Report of the meeting of the Development Control Post-Committee Site
Inspection Panel held on 13-OCT-2009

REF NO: **A/78/09/**

LOCATION: 101 Lloyd Goring Close & land to rear
 of 7-15 Lansdowne Way
 Angmering

PROPOSAL: Terrace of 4 no. 2 bed houses - resubmission following A/75/08/

EAST 1/100

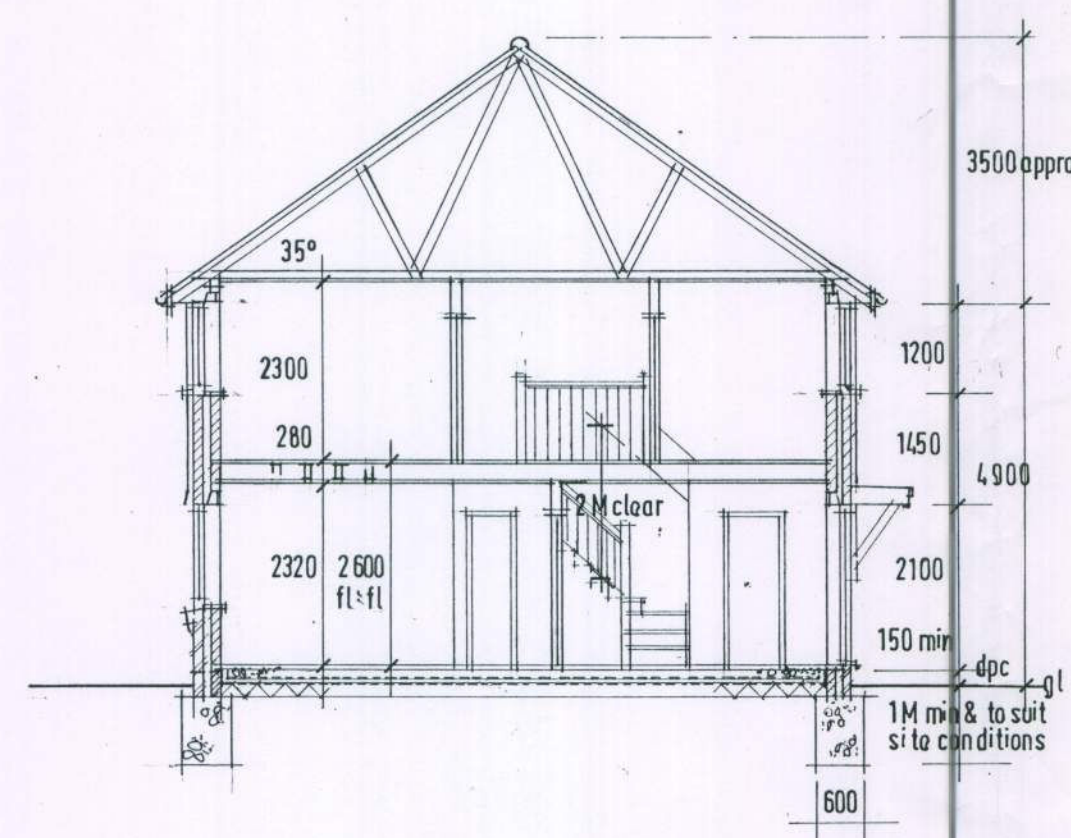
Unit No.1 would have a secondary staircase window at first floor facing onto the rear garden of No.17. Whilst the potential for direct overlooking would be low, it is proposed to condition this window is obscure glazed to protect the privacy of Nos. 17 Lansdowne Way and 99 Lloyd Goring Close.

- 7 The first floor window on the east elevation of the building shall at all times be glazed with obscured glass.

BLOCK PLAN 1/500

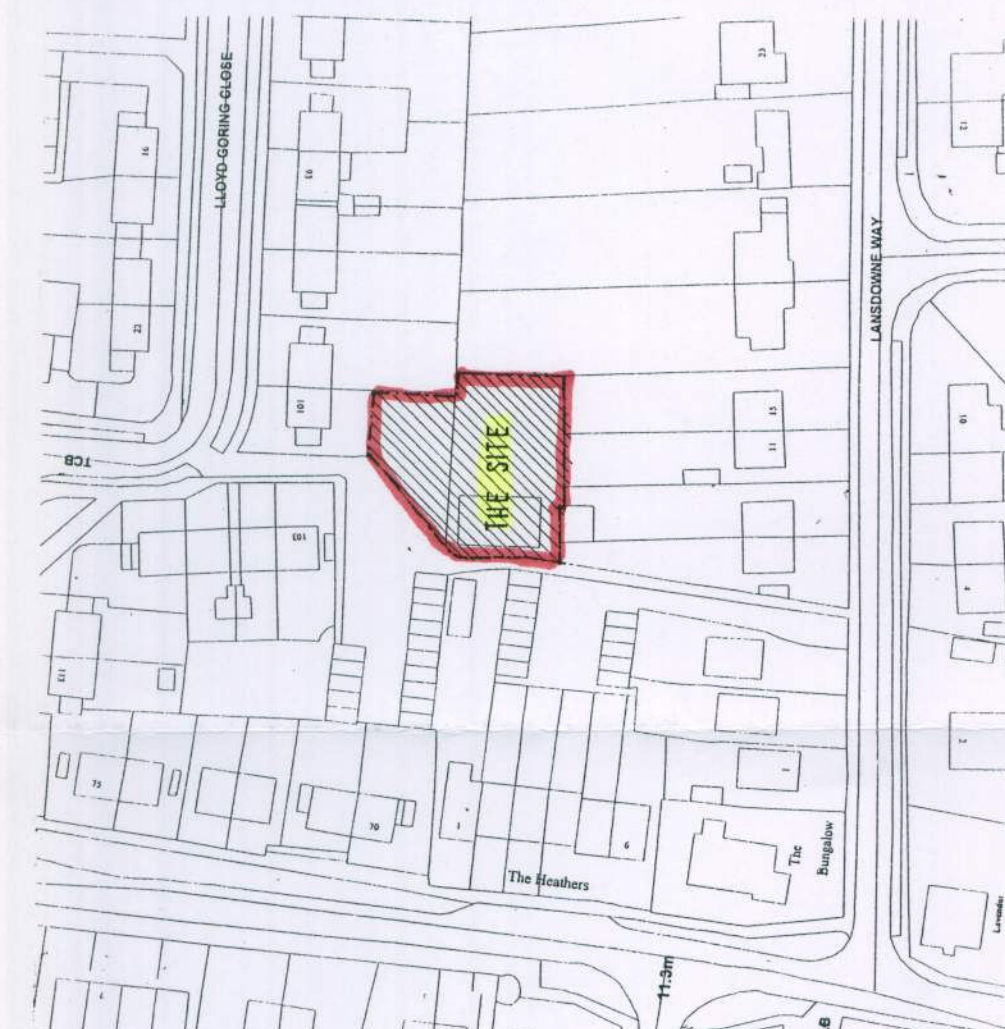
Parking and turning would take place to the rear of 101 Lloyd Goring Close and adjacent to the rear side boundary of No.99. Subject to adequate boundary screening in this location, vehicle movements in this vicinity would not cause material harm to residential amenity from noise.

- 4 No development shall take place until details of screen walls and/or fences have been submitted to and approved by the Local Planning Authority and no dwellings/buildings shall be occupied until such screen walls and/or fences associated with them have been erected.

STANDARD BACK GARDEN SITED CYCLE STORE
TO ACCOMMODATE 2 N° CYCLES
SCALE 1/50

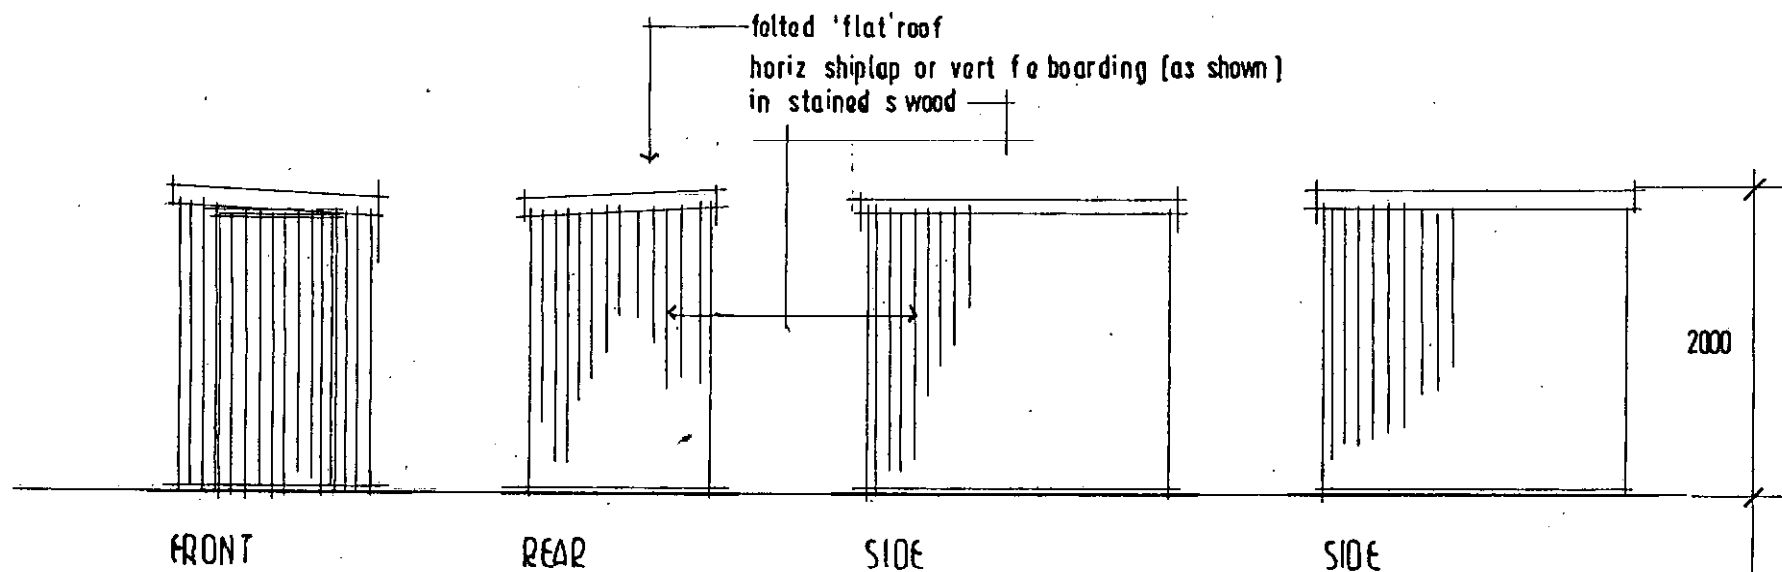
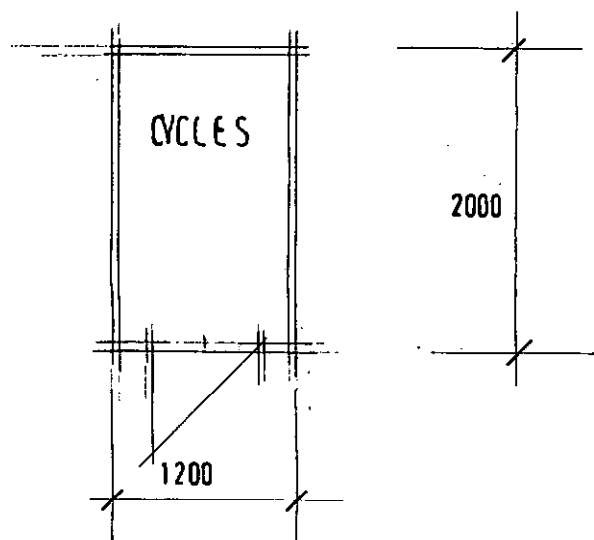
County Highways - No objection. Proposal does not exceed parking standards. Area of hardstanding is adequate. Cycle parking should be at a ratio of one space per bedroom. No significant highway safety issues are anticipated. In terms of transport, site is in a sustainable location. Informative and condition suggested.

- 2 The buildings shall not be occupied until the parking spaces and turning facilities shown on the submitted plans have been provided and constructed and the cycle stores (indicated on the drawing submitted on 27-07-2009) have been provided. The areas of land so provided shall not thereafter be used for any purpose other than the parking and turning of vehicles and storage of bicycles.
